ENG-SF21012-R2-FDR-redlines.pdf Markup Summary

### EXISTING DRAINAGE MAP

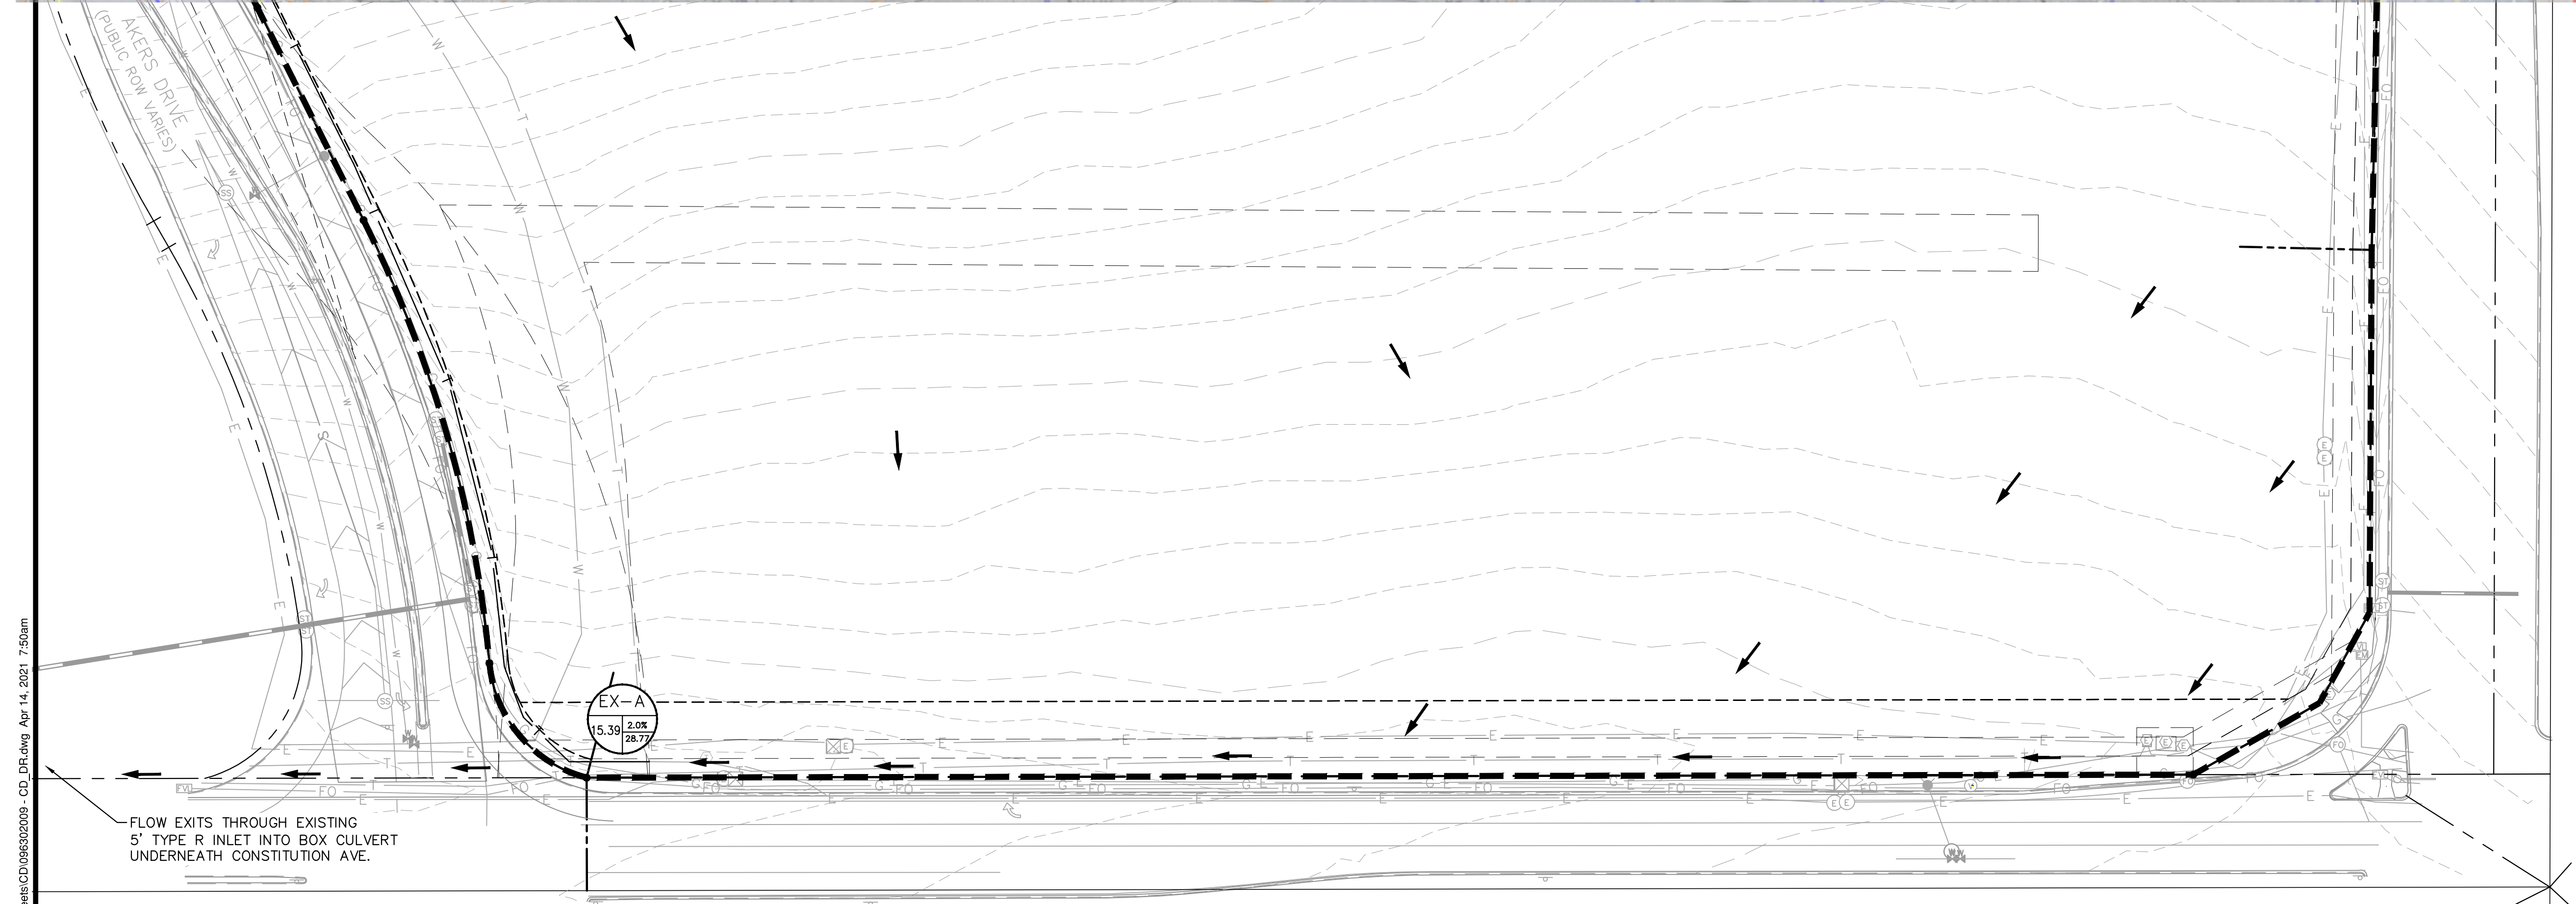
Most of the flows from that
site drain into the subject
site don't they?
